Your ref:
Our ref: H4977/RAM/sg
Date: 5 March 2021

re: 13 – 17 High Street, Wisbech, Cambs

SECTION A-A
1:50

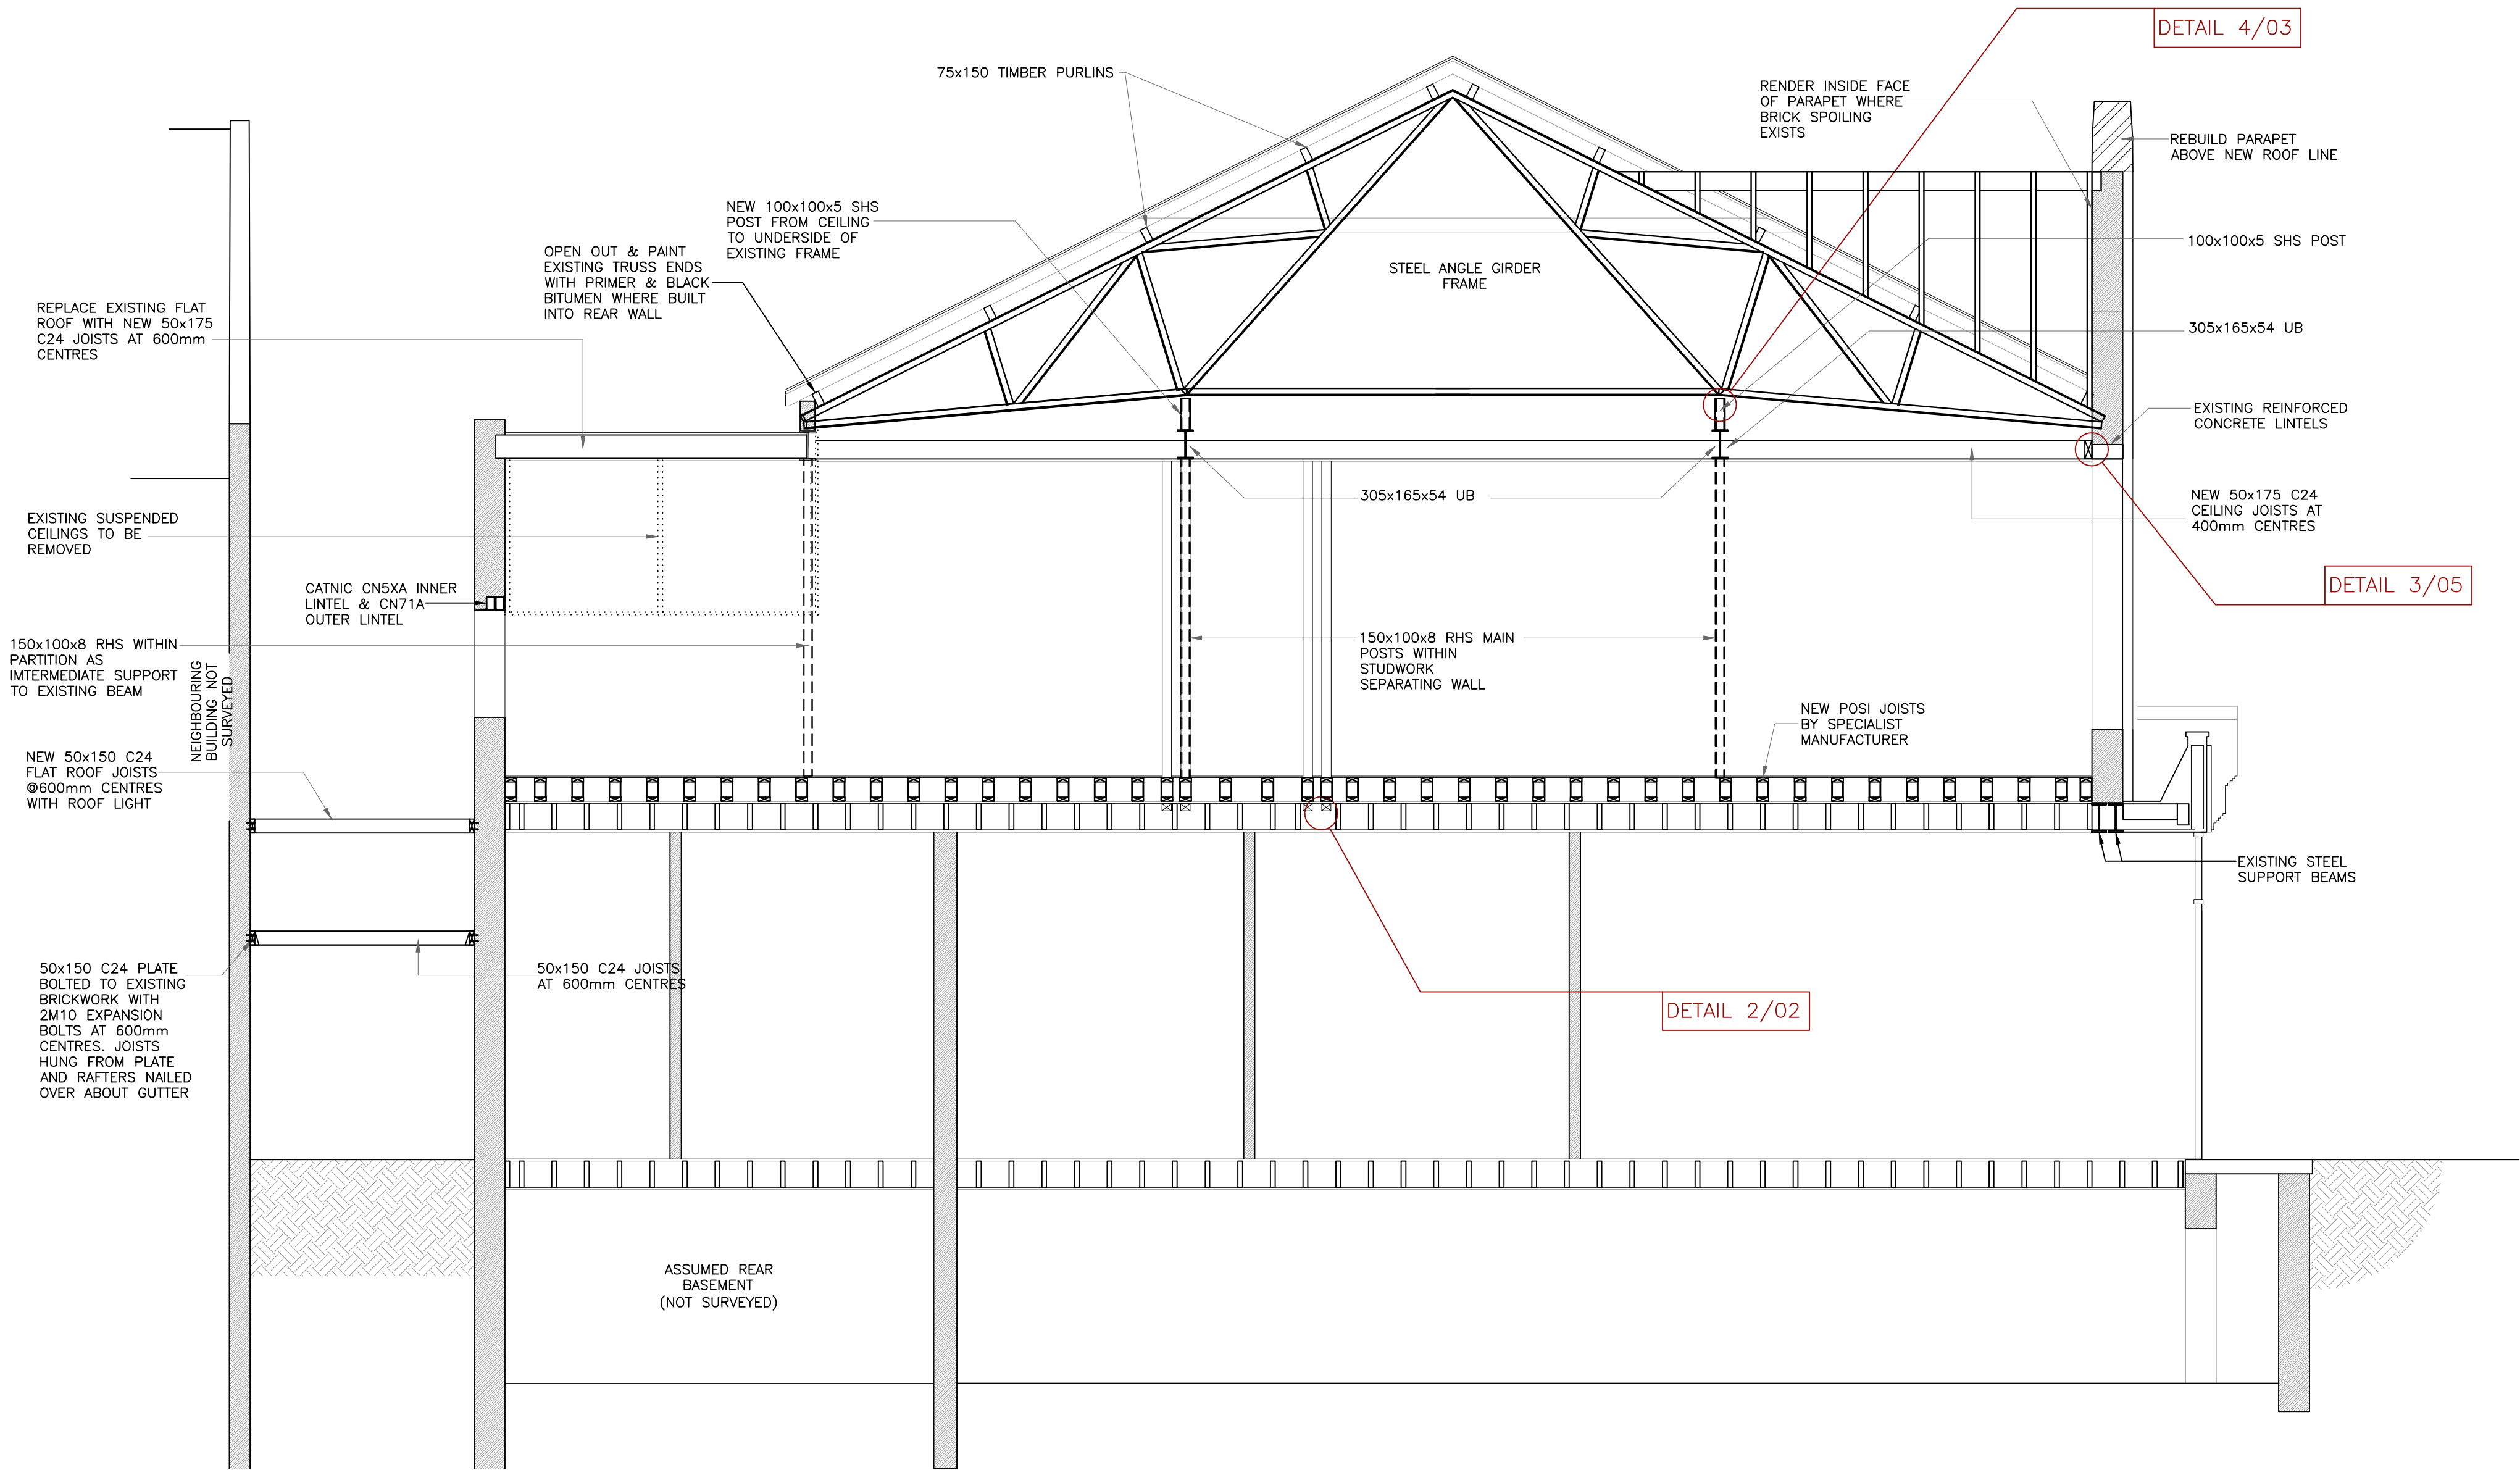
ST1 Group Ltd have also raised queries with regards to underlying issues that caused this movement to the parapet wall.

This was basically due to a slender wall being too high. There was only a tie bar but this also needed to be a strut propping back to the roof and the tie bar had buckled.

The wall was able therefore to rotate. There was also considerable erosion arising.

The new roof will however brace the wall and give adequate support.
